CITY OF ALBUQUERQUE

December 1, 2011

Re: Sawmill Crossing, Conceptual Grading Plan
Engineer's Stamp dated 11-10-11 (H13/D057)

Sawmill Residential

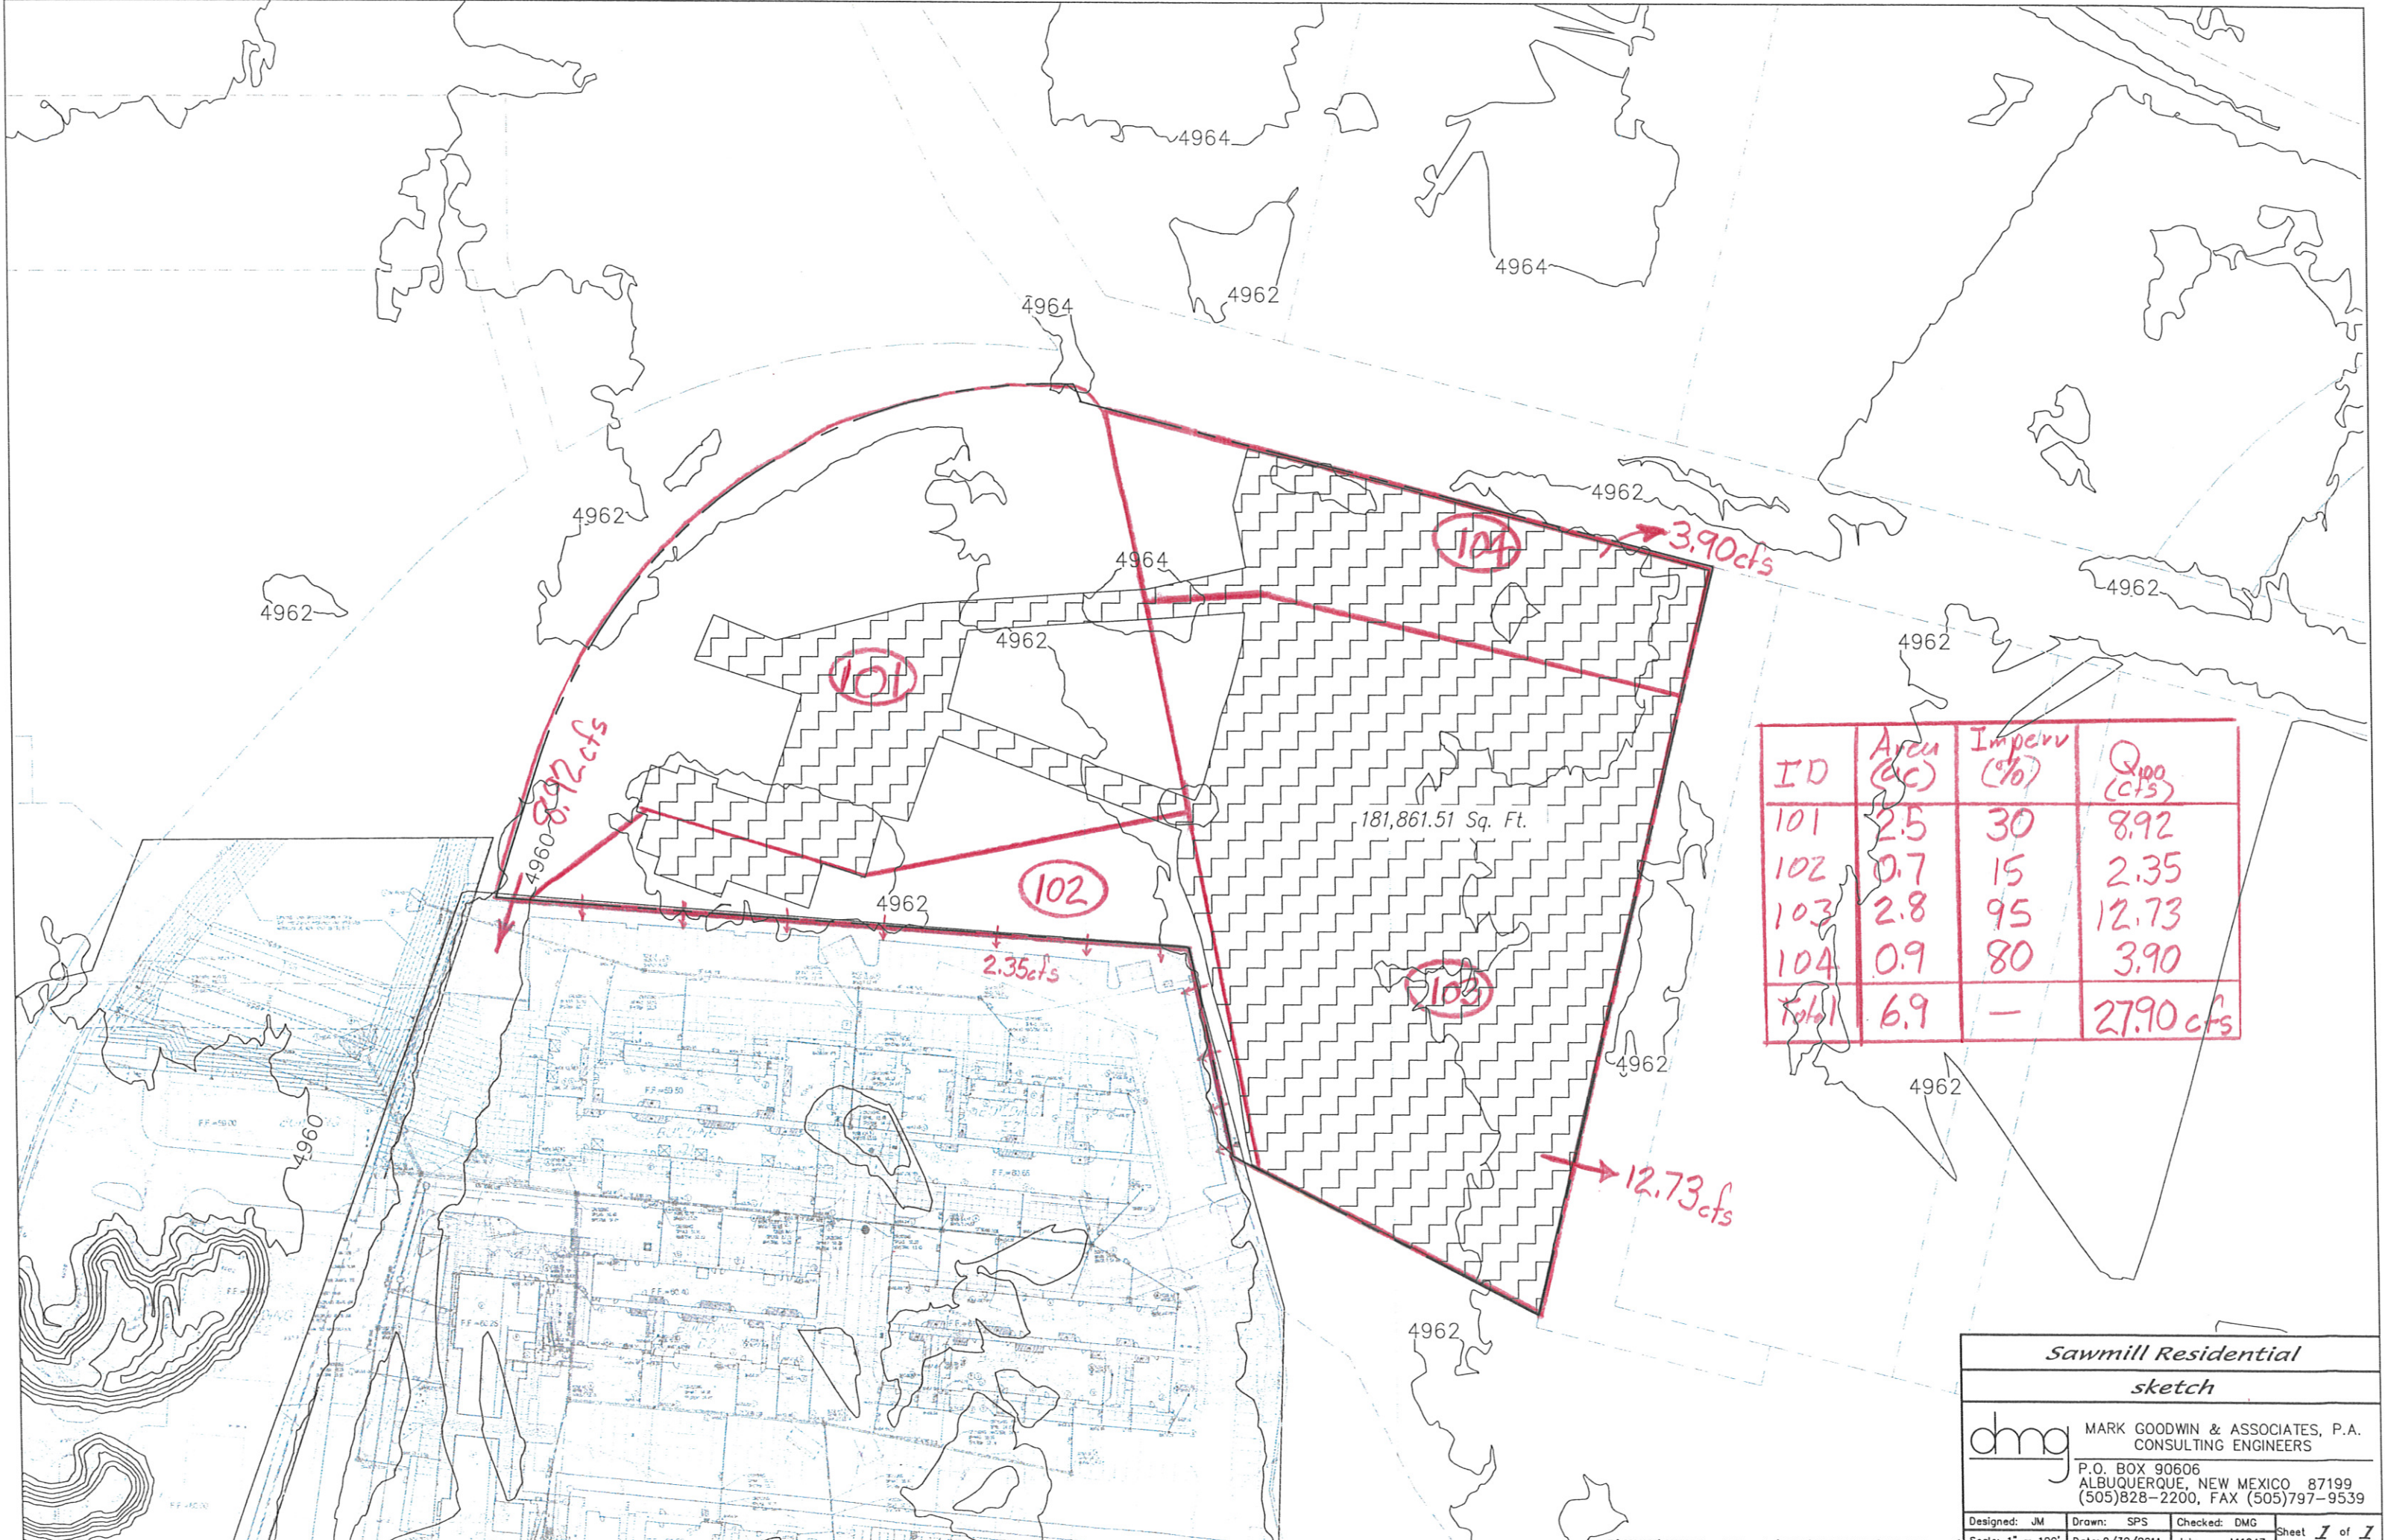
Based upon the information provided in your submittal received 11-10-11, the above referenced plan cannot be approved for Site Plan for Subdivision action by the DRB until the following comments that were presented at the 11-16-11 DRB meeting are addressed:

- Meeting the ponding requirement will be more difficult with the proposed zoning. Hydrology would prefer to keep the existing zoning.
- Residential zoning may be possible with a neighborhood pond.
- Proposing public streets with this design will cause a mixture of Public and Private stormwater. That is undesirable.
- The Conceptual Grading Plan states to use 70% impervious, whereas the DPM has a max of 45% for the flat grading scheme. The proposed development is too dense to accommodate the ponding required.
- Homeowners are regularly filling in ponds on their lots. Hydrology would prefer to see a more centralized neighborhood private pond. The pond could double as a park.
- Why does the plan propose to fill so much at the south west corner? This is a historic outfall location.
